June 17, 2009
DRB Comments

PROJECT # 10007697 APPLICATION # 09-70193

RE: Lot 3, Block 66, University Heights

DRB CASE NO/PROJECT NO: 1007685

Project No. 1007697

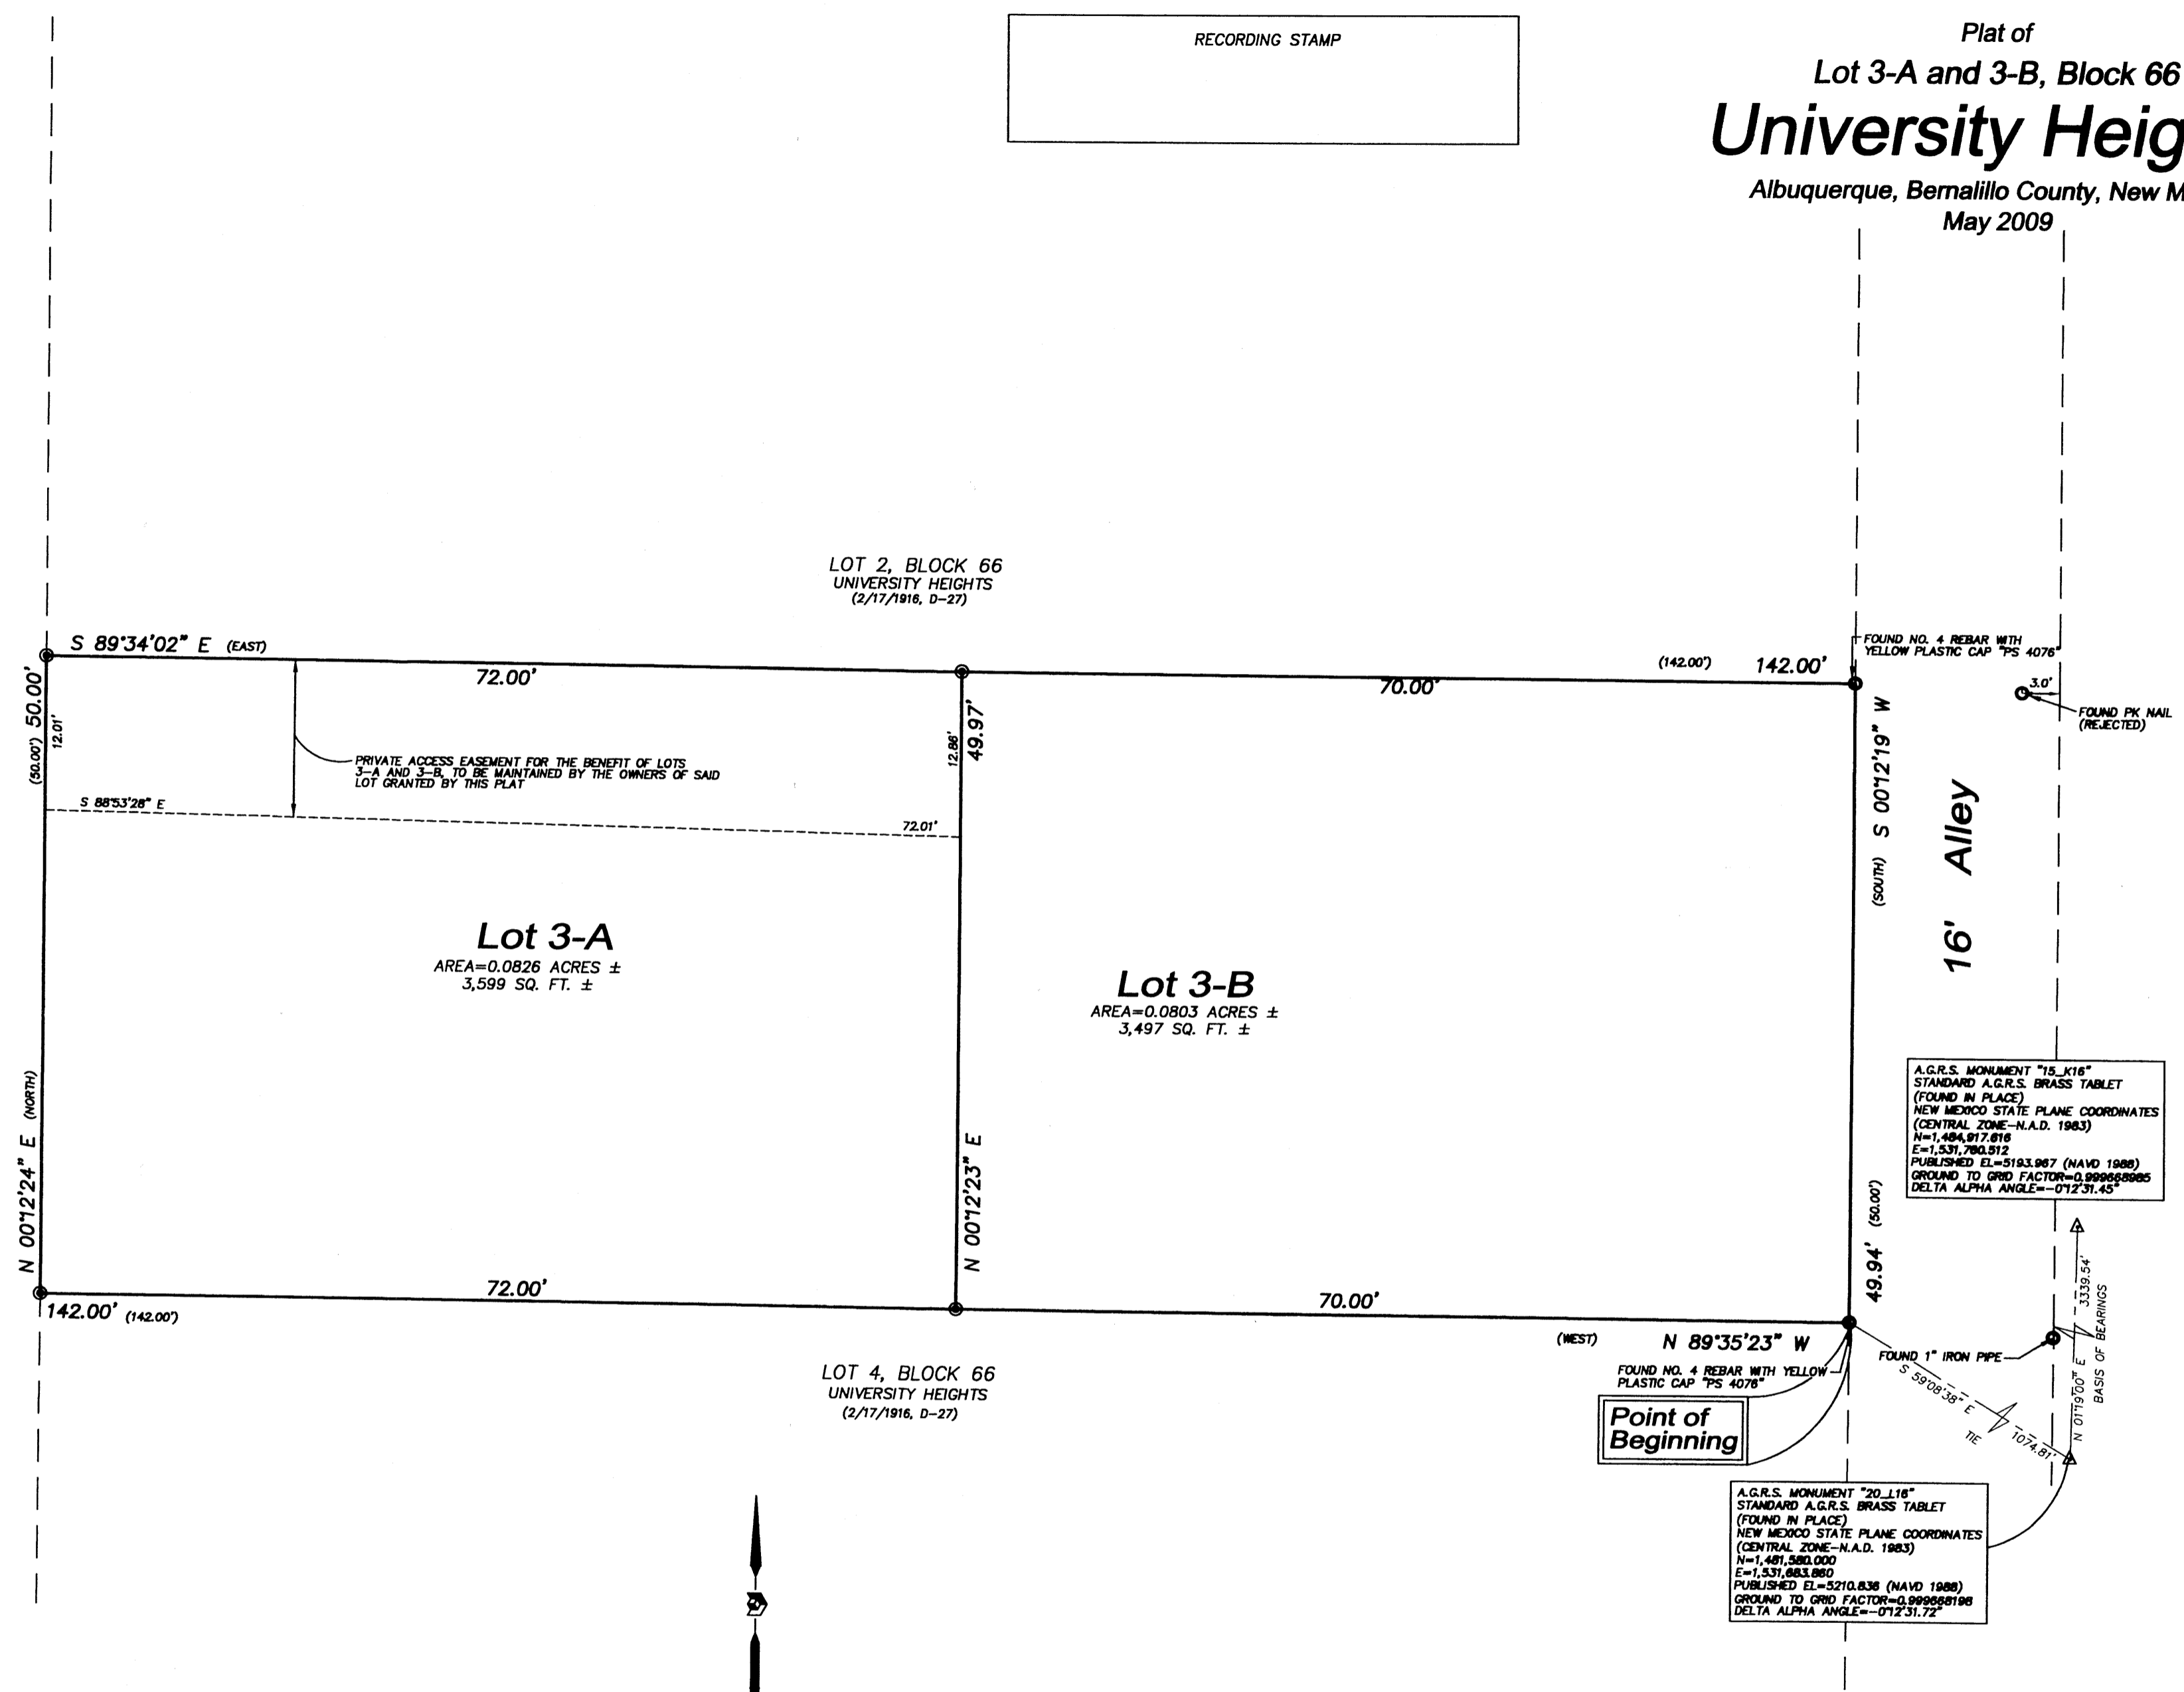
A copy of the ZHE decision is needed for this DRB file; that case
should also be referenced in the Disclosure Statement (add
“*CONSISTENT WITH 09ZHE-80076.*” at the end of the statement).

Minimum Access Easement width is 15 feet.
